**WELWYN HATFIELD BOROUGH COUNCIL – DEVELOPMENT MANAGEMENT  
DELEGATED REPORT**

<b>APPLICATION No:</b>	<b>N6/2013/1654/FP</b>
<b>APPLICATION Site:</b>	<b>2 Mulberry Mead, Hatfield</b>

This application seeks planning permission for the erection of a two storey side extension.

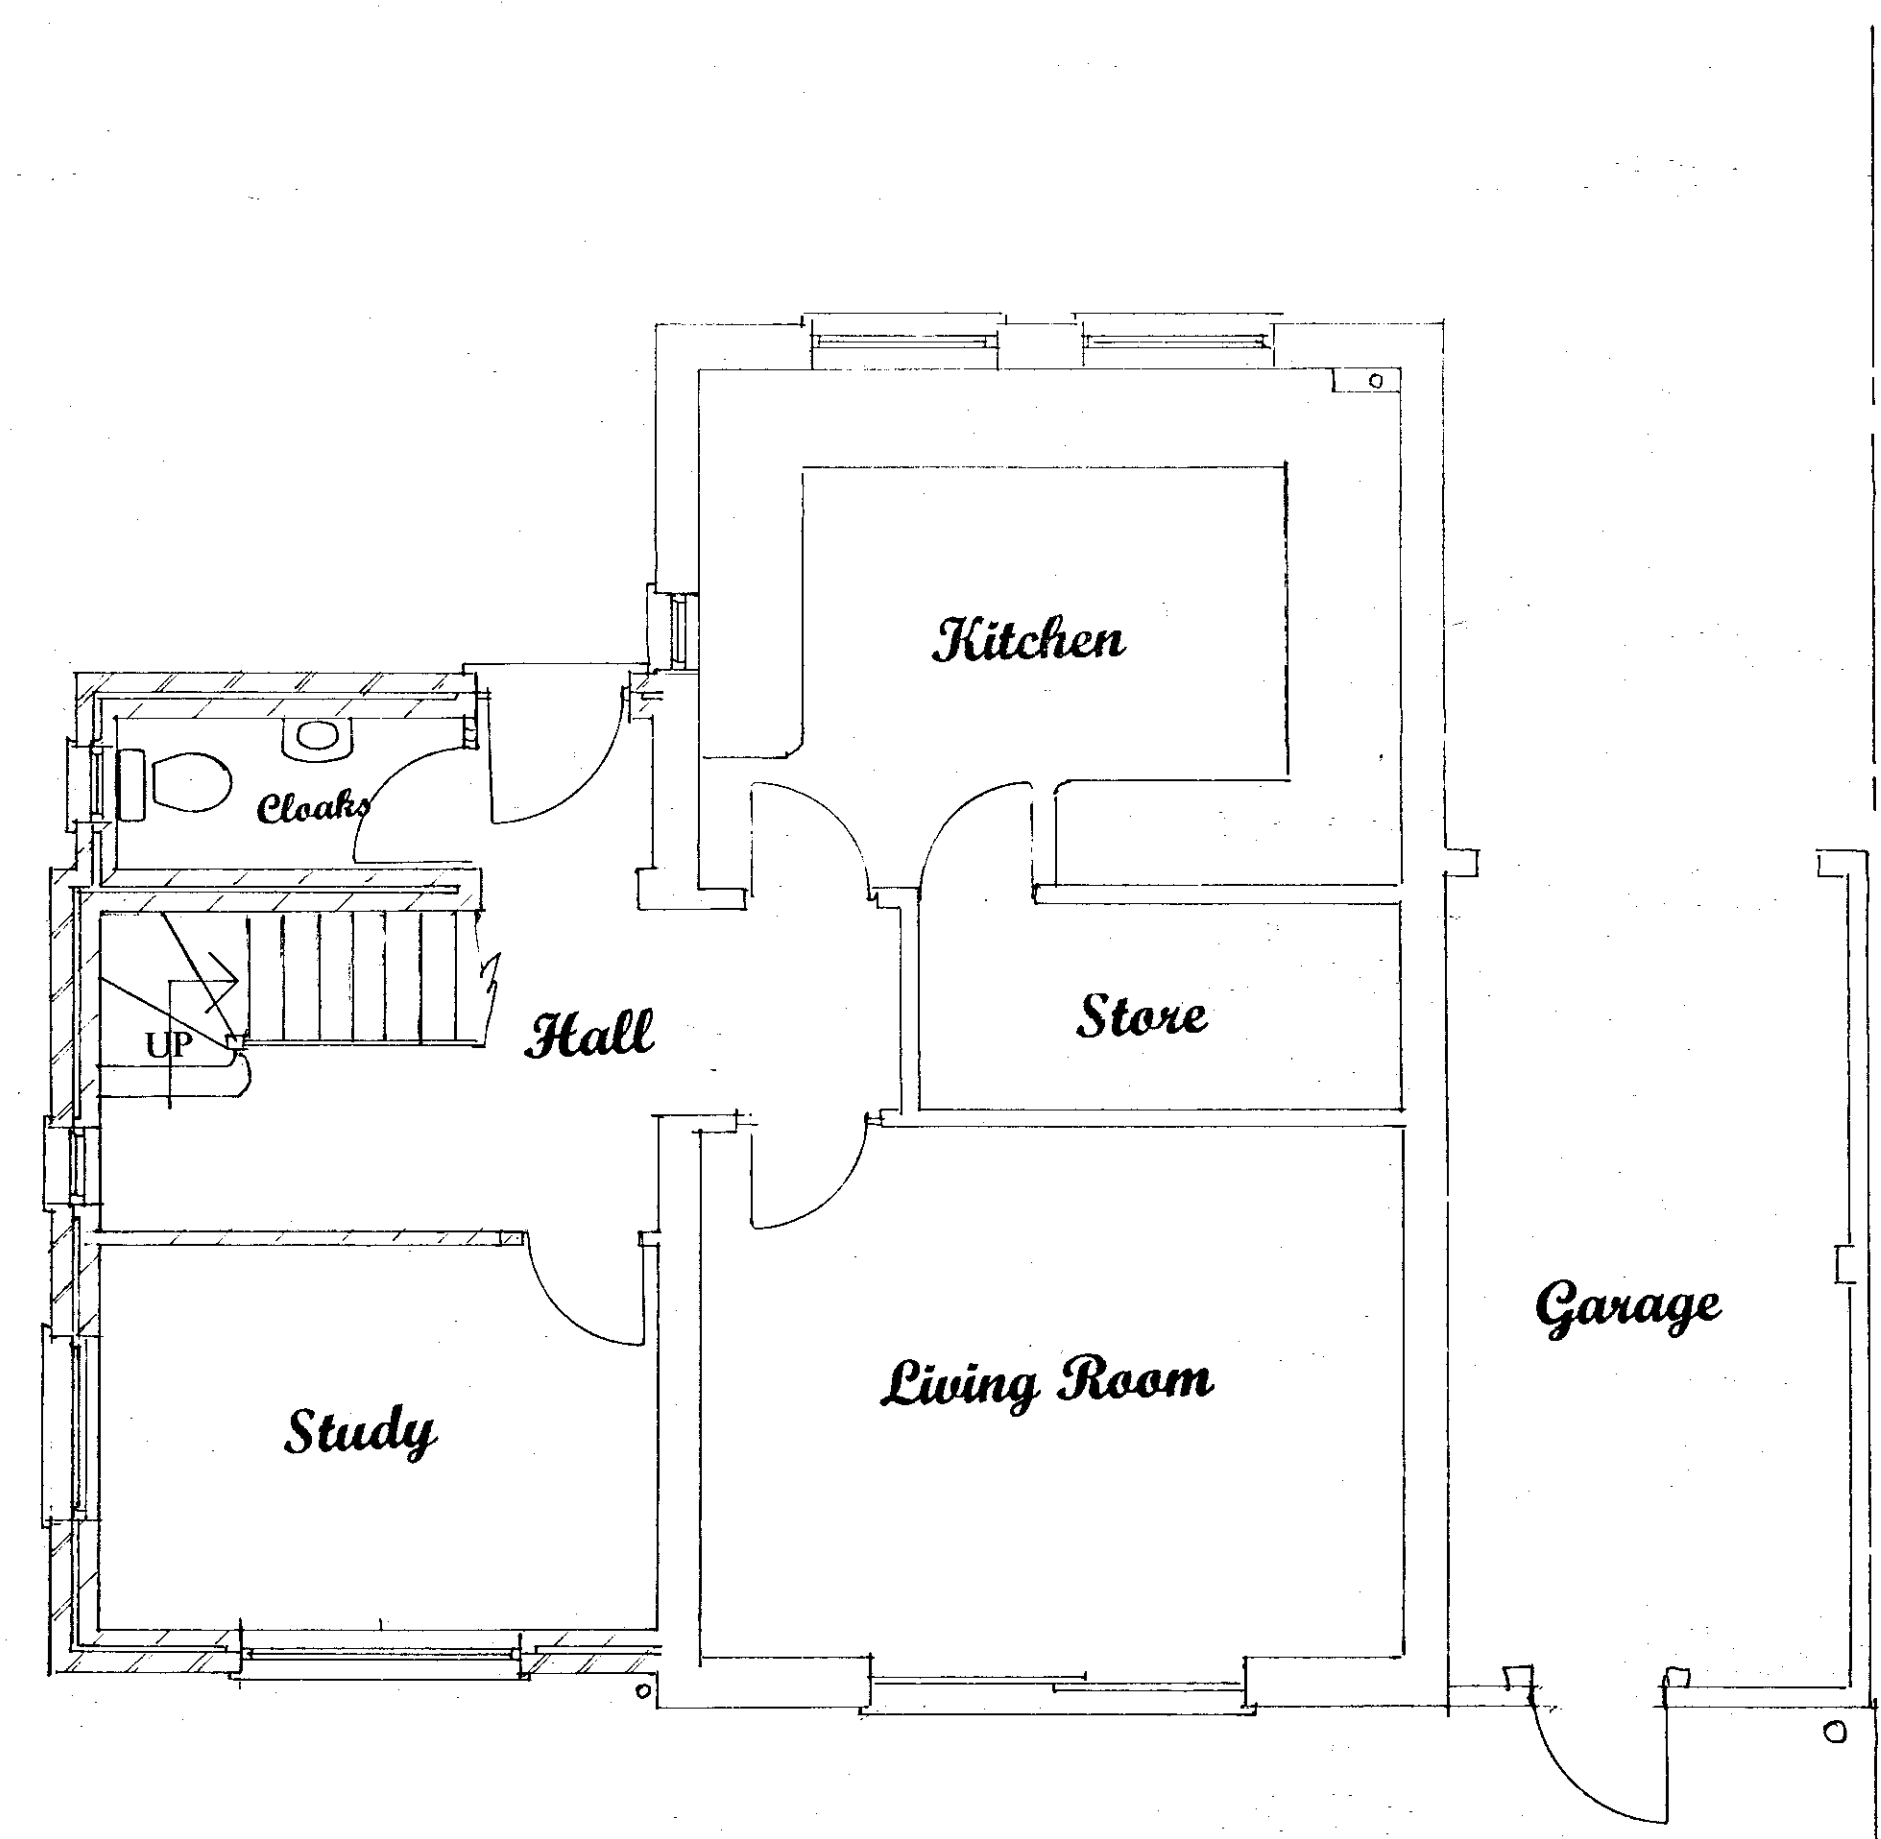
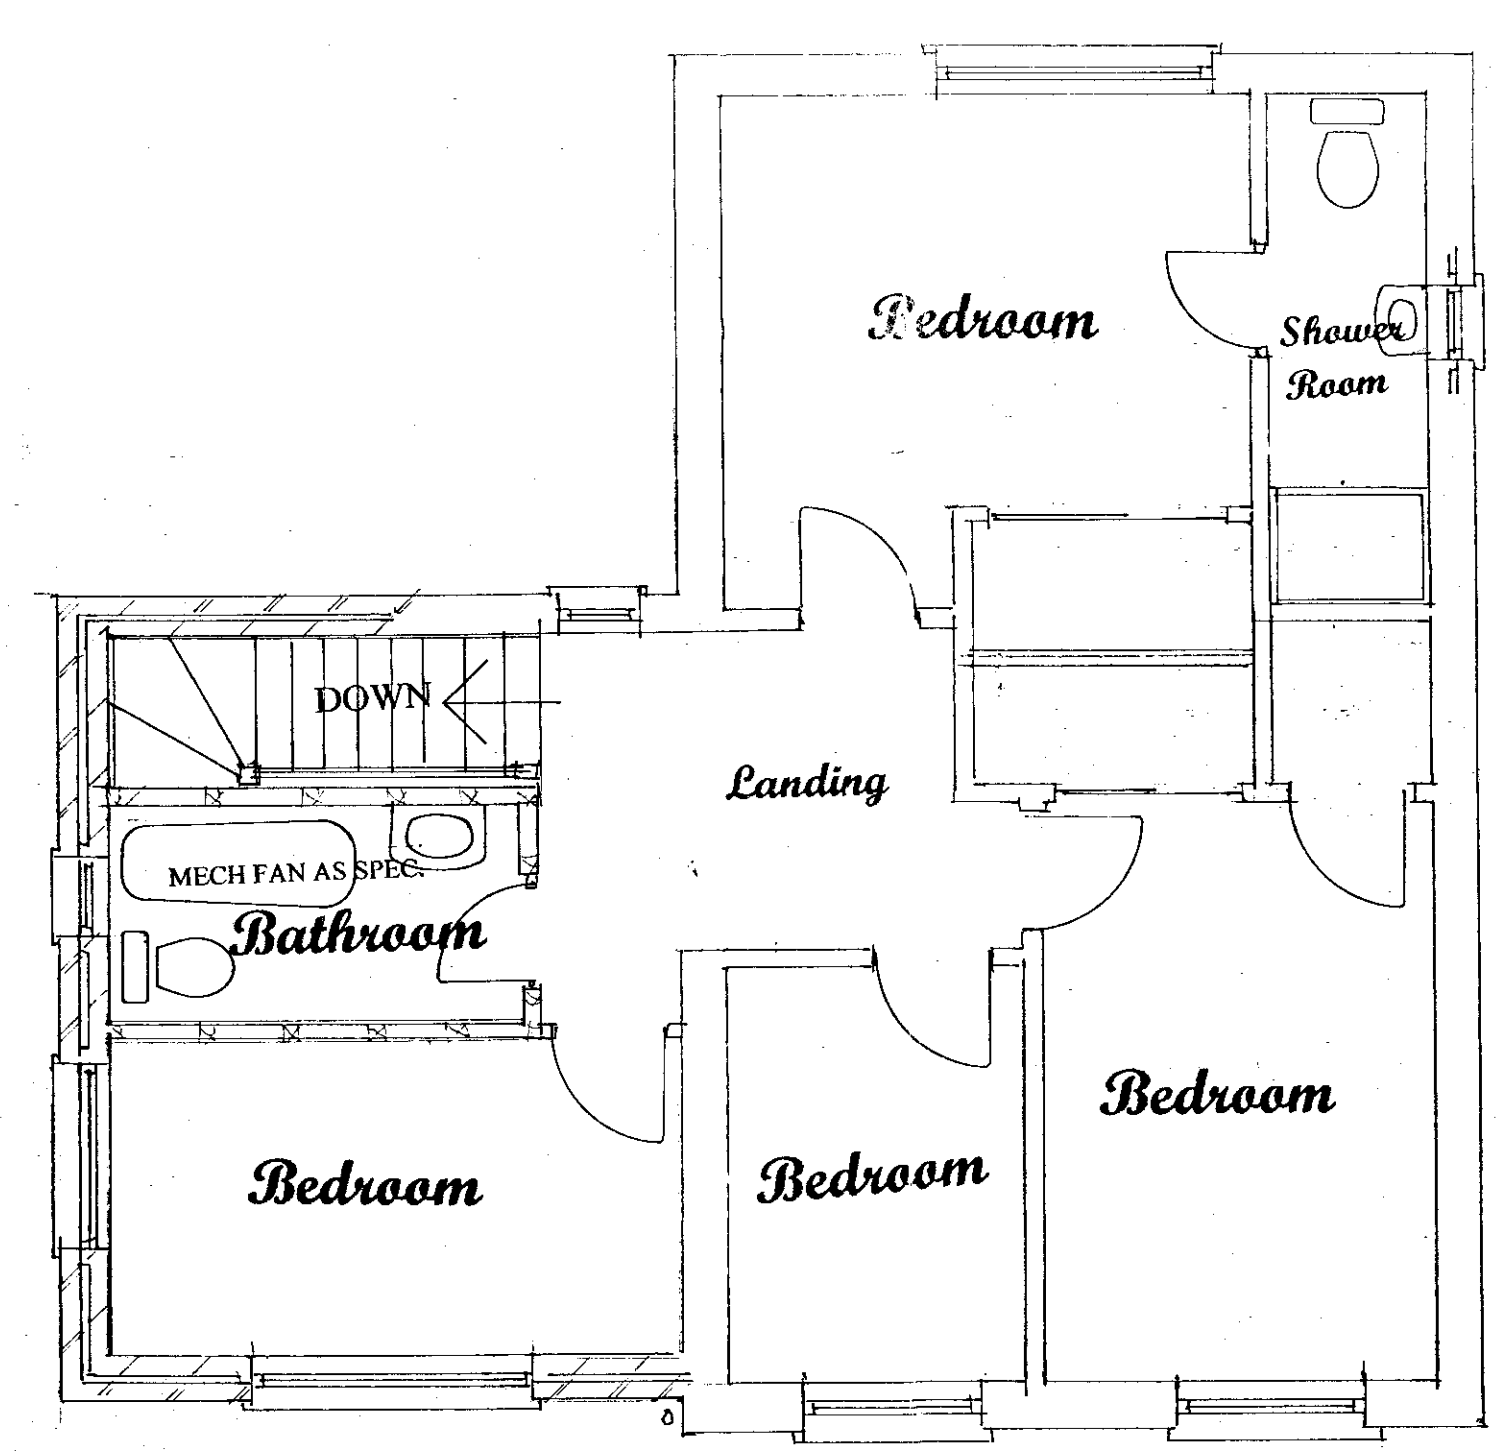
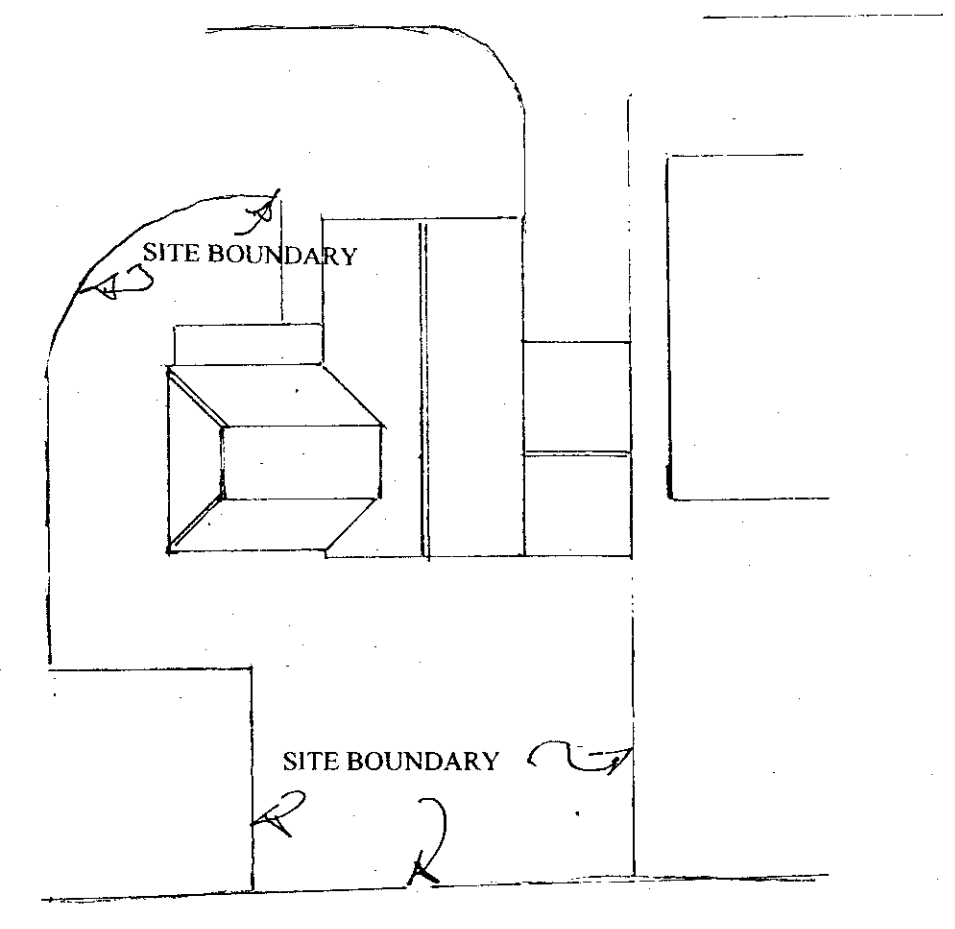
The plans have been revised during the course of the application. Alterations have been made to the roof design to reduce the overall height of the side extension and help make the extension appear subservient to the original dwelling.

Following negotiation with the architect, the plans have been revised to lower the overall roof height of the proposed side extension. The host dwelling occupies a prominent corner plot location, near to a roundabout which joins 4 roads. Views of the side of the dwelling are therefore available from a large number of points. The proposed side extension is relatively large in size in comparison to the original dwelling but the lower roofline reduces its overall bulk and scale when viewed against the original dwelling and helps make it appear subordinate in scale, in accordance with the Council's design guidance. There is a landscape buffer zone to the side of the host dwelling and therefore it is not considered that the extension would lead to the host dwelling appearing cramped on its plot. Furthermore, the hedgerow which marks the boundary between the landscape buffer zone and the pavement screens the application site to some extent.

1. C.2.1 Time limit for commencement of development
2. C.13.1 The development/works shall not be started and completed other than in accordance with the approved plans and details: Drg. No.01 received and dated 1 August 2013 and Drawing No.02A received and dated 20 September 2013 unless otherwise agreed in writing by the Local Planning Authority.
